REPORT UPDATE

Application No: FG/115/17/PL

LOCATION: 44 Ferringham Lane
Ferring
BN12 5LU

PROPOSAL: 4 No. bungalows

SCALE 1:200 @ A1
DATE 14.05.2017
DRAWN sed
DWG No. 628-02 rev. E

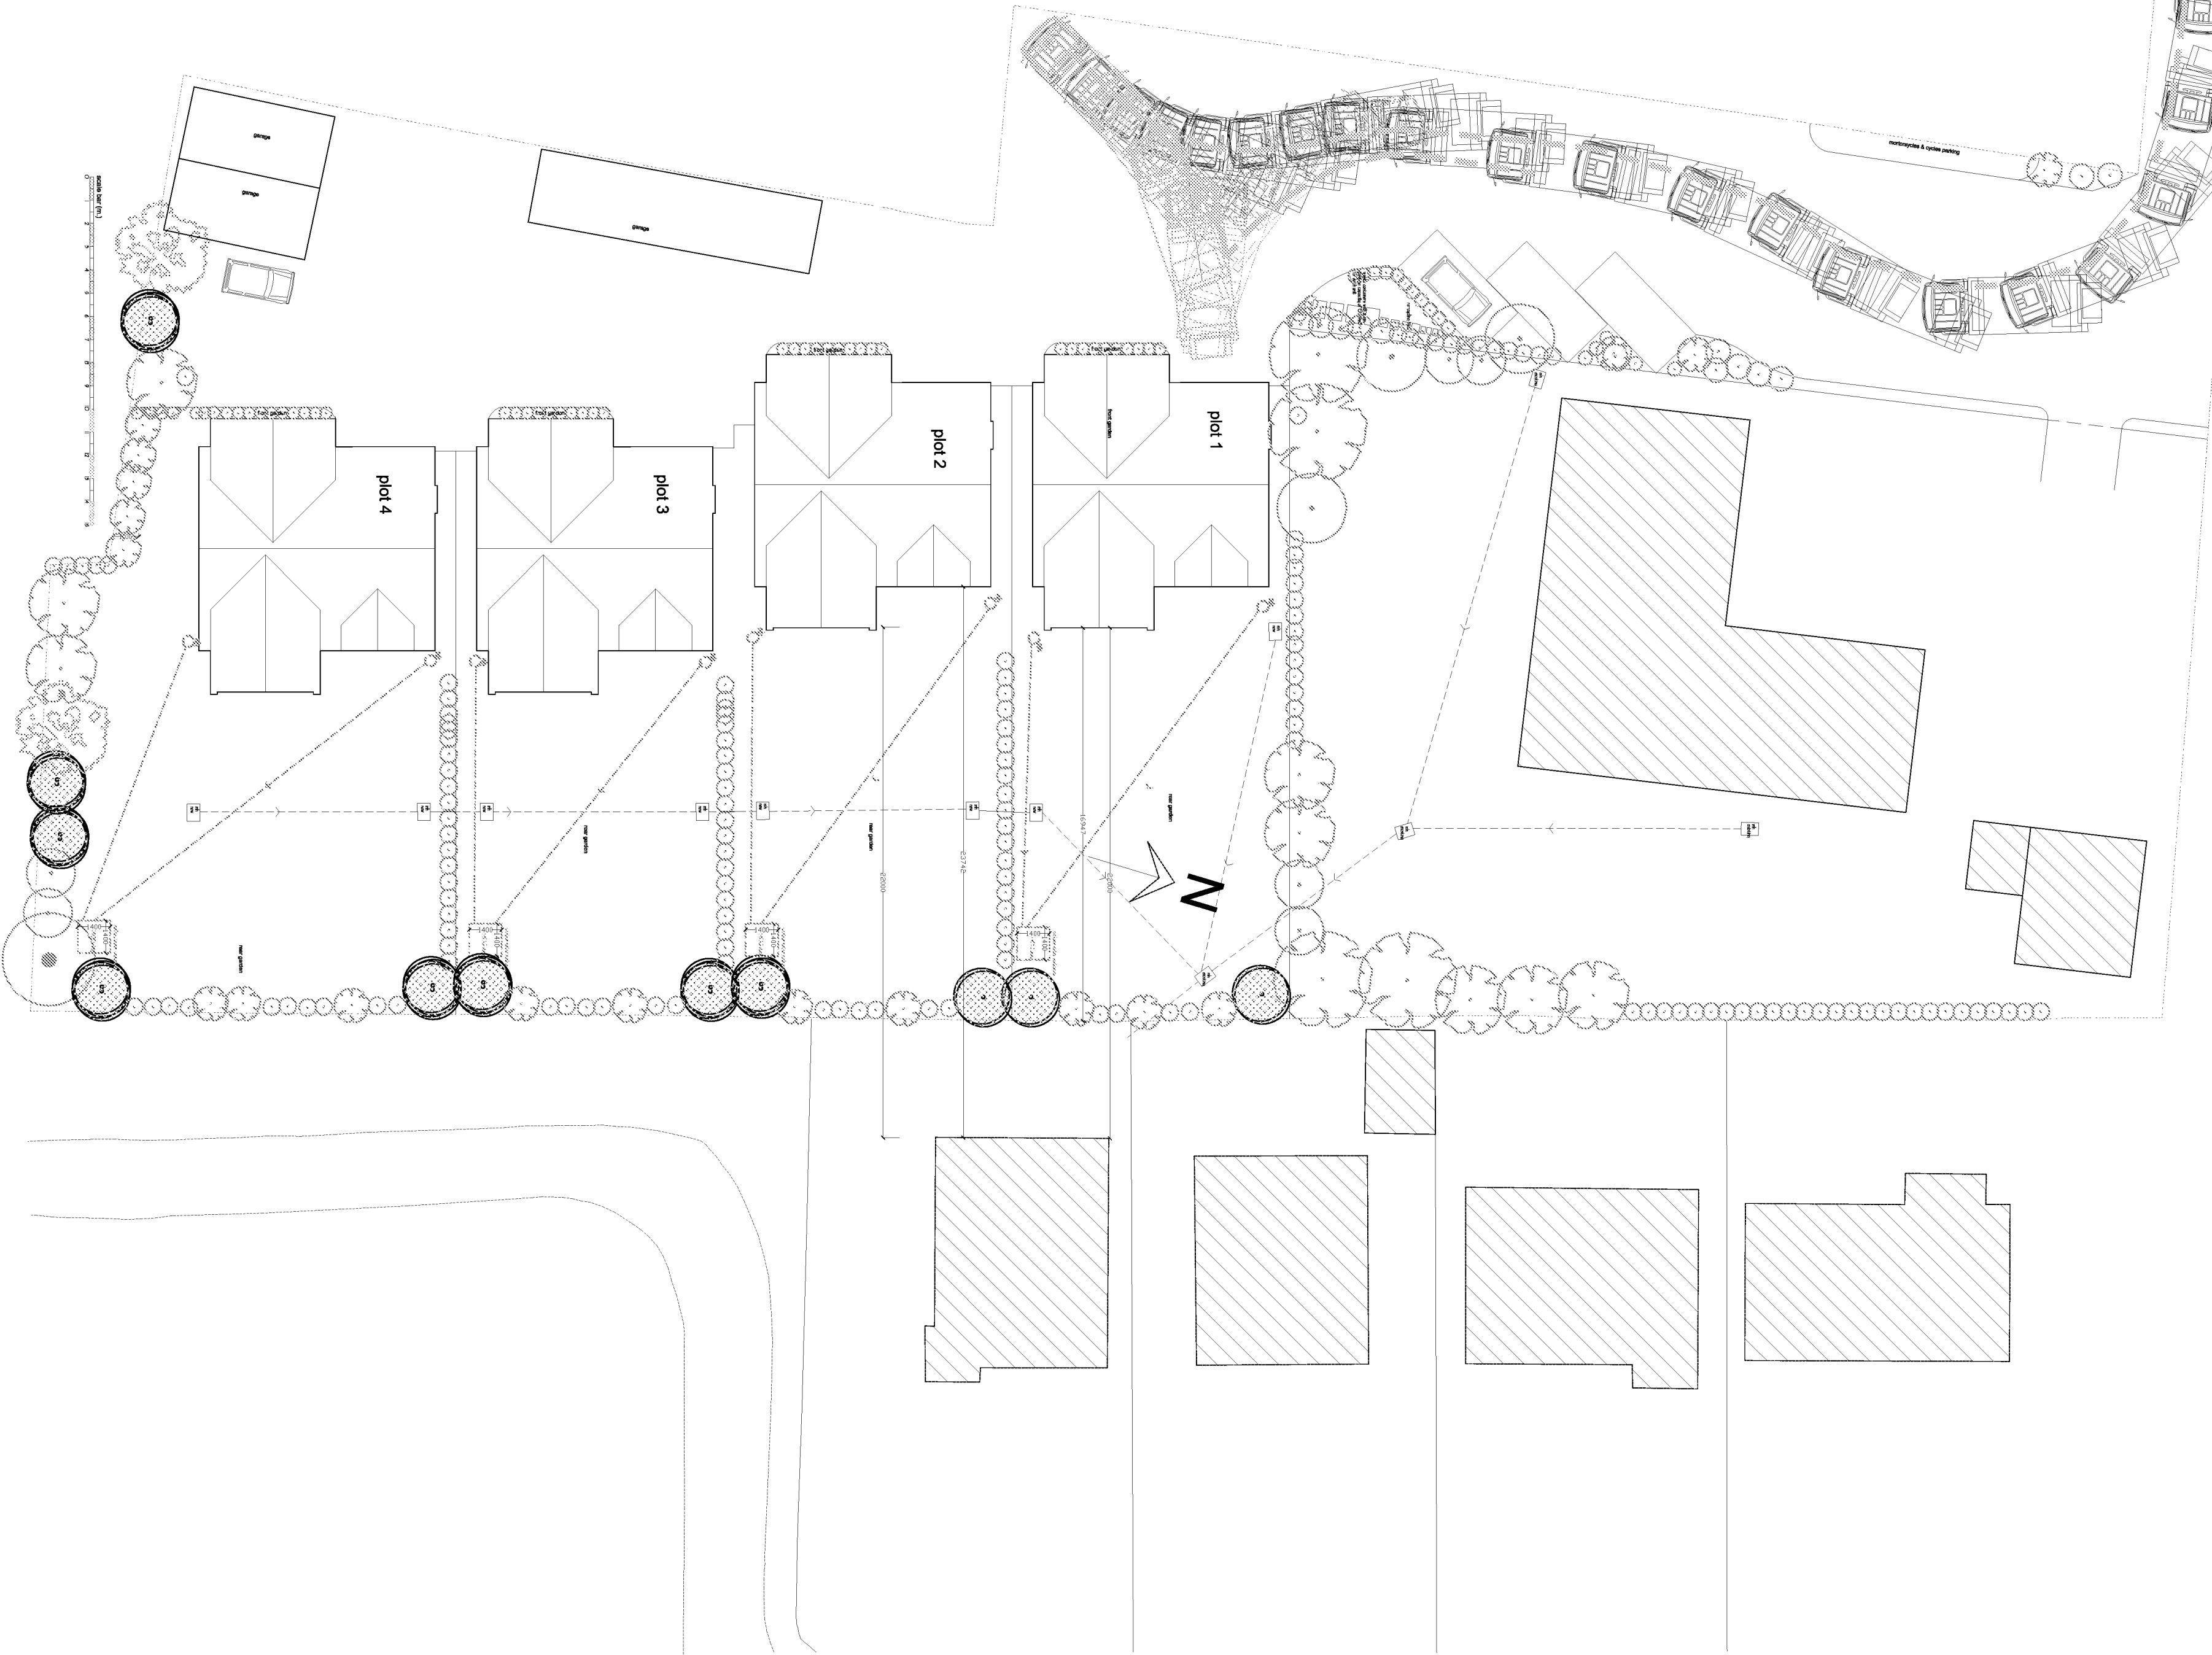
County Highways have been re-consulted on the revised parking layout and have made the following comments:

From scaling the plan (628-06) this will leave 2.88 metres between the planting for plot 2 and the north eastern corner point of the garage. This would be enough internal width for a vehicle to pass. By way of some proxy guidance building regulations allow internal access to be reduced to 2.75m over a short distance, so a car or other private vehicle will be able to fit through.

It's been accepted that two spaces per dwelling and three visitor spaces is acceptable to meet the needs of the development. I would be minded to accept that such a provision is still available on the internal hardstanding even with the revisions to dwelling placement, though it is getting very restricted and opportunity to provide suitable parking spaces is getting diminished by the pushing forwards of plots 1 and 2.

Each dwelling is provided with a garage space so that means 4 spaces need to be provided somewhere on the remaining hardstanding area.

Theoretically spaces can be provided in parallel fronting plots 3 and 4 though as previously observed such spaces should measure 3 x 6 metres and this is not available with the design shown. These spaces would likely be useable but would require some manoeuvring to access.

There is also space adjacent to the garage at the southern extent of the plot outside plot 4 to park two vehicles. One additional echelon space could also be provided where the visitor parking area is.

Given none of the above has been shown I would be minded to suggest getting a formal parking layout plan provided and approved. I would not recommend any parking fronting plot 1 as this has been

indicated at the turning area for larger vehicles. Similarly any parking fronting plot 2 or in front of the northern most garage is going to further impede access to plots 3 and 4 so would not be recommended.

Where this development is accessed via a private road WSCC would not be able to offer a formal objection to the proposed. The applicant and Local Planning Authority should consider the points raised above and consider the impacts of the layout proposed whereby parking for plots 1 and 2 is being pushed away from the dwellings which may not be the most ideal and convenient parking solution for future occupiers.

These comments were discussed with the agent and further substitute plans have been submitted relating to the deletion of part of one of the garages and the addition of indicative parking and landscaping. The parking layout indicates that 2 parking spaces/garages are provided per dwelling with 3 at the entrance to the development for visitor parking.

The parking condition (no. 6) has been amended to include submission of details of the parking layout to ensure that these details can be discussed further with County Highways to ensure that the spaces are accessible .
